PROJECT NAME: **The Vista West PBCP (CL-09-01)**

STAFF REPORT (*Revised from Dec. 9, 2010*) VISTA WEST PERFORMANCE BASED CLUSTER PLAT

TO: Kittitas County Hearing Examiner
FROM: Kittitas County Community Development Services Staff
RE: Vista West Performance Based Cluster Plat (CL-09-01)
DATE: May 26, 2011 Hearing

VISTA WEST
PERFORMANCE BASED CLUSTER PLAT
A PTN. OF THE NORTH 1/2 OF SEC. 33, T.20N., R.14E., W.M.
KITITAS COUNTY, WASHINGTON

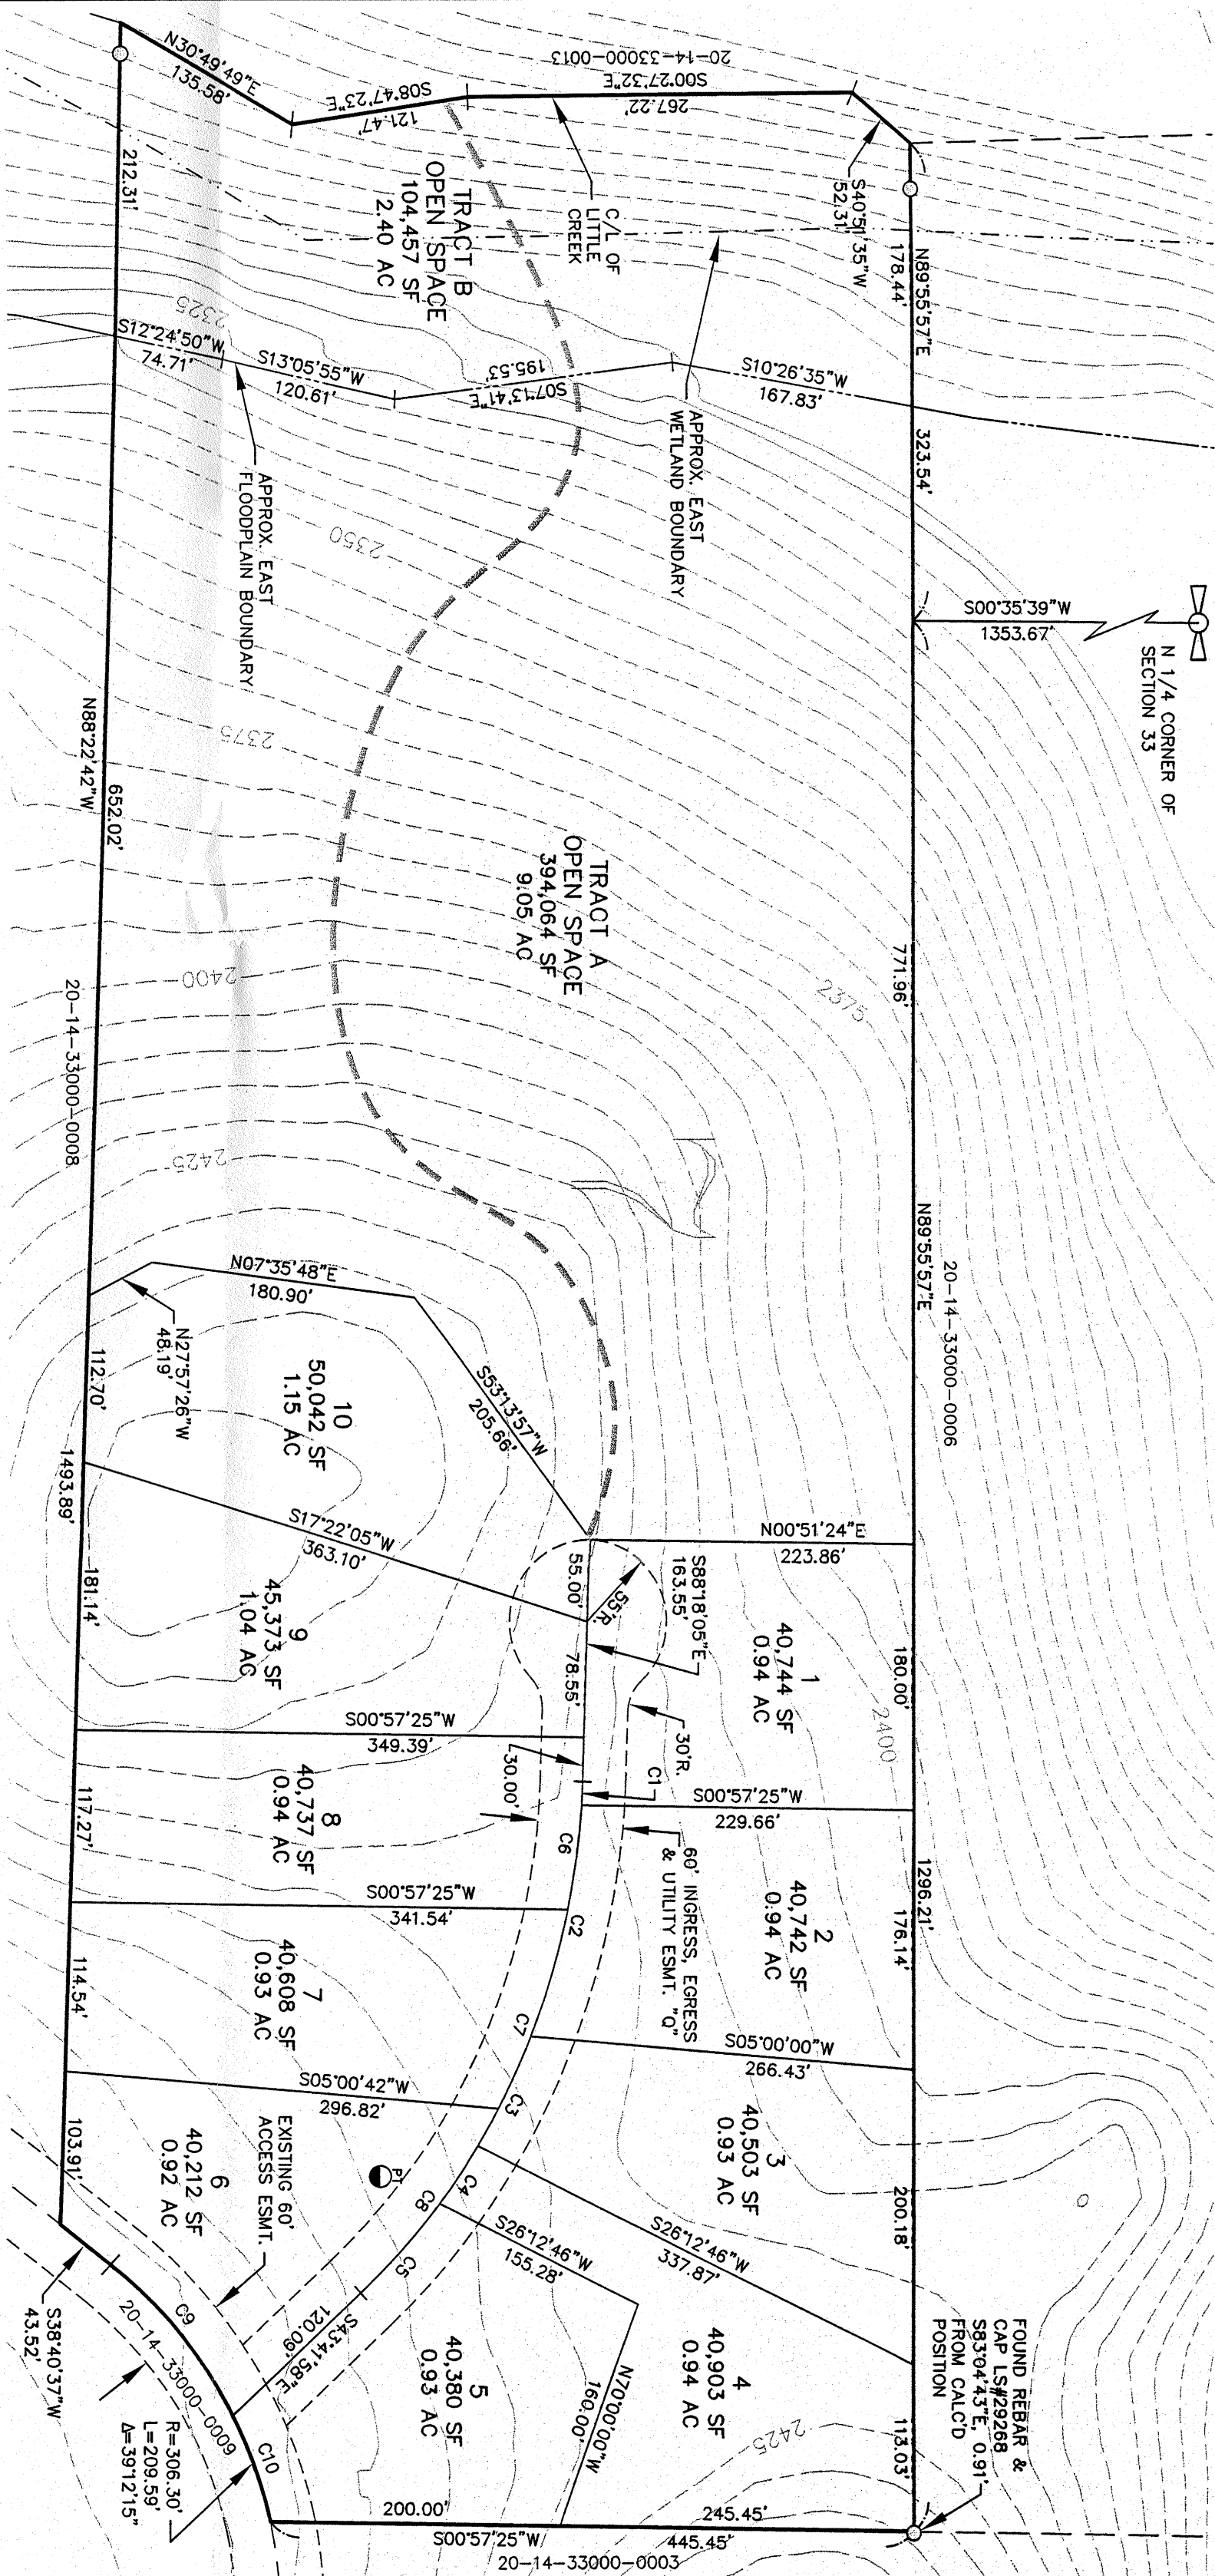
6. Wetland Impacts: The proposed plat area contains a wetland area along Little Creek. No development is proposed in this mapped wetland or within approximately 600 feet. The plat shows a trail passing through the wetland and across Little Creek, and notes this trail is possible for future construction "at the discretion of the owner." Construction of this trail will require compliance with Title 17A Critical Areas.

7. Flood Prone Areas: The project site contains frequently flooded areas associated with Little Creek, which is under the jurisdiction of the County's Shoreline Master Program. No lots are proposed within the floodplain boundary, but a trail for possible future construction is shown. Any development within floodplain associated with Little Creek is subject to 17A.05.020 "No net loss of floodplain storage" and applicable provisions of the Conservancy environment included in the Shoreline Master Program.

8. Future Trail Construction: The following note shall be placed on the face of the final plat:

The approval of CL-09-00001 does not authorize construction of the proposed trail system noted as "future construction at the discretion of the owner." The proposed trail passes through a wetland, floodplain, and "Conservancy" shoreline environment. Trail construction shall be subject to County review and approval for compliance with Title 17A Critical Areas and the Shoreline Management Program, and additional wetland and flood storage analysis may be required prior to trail construction.
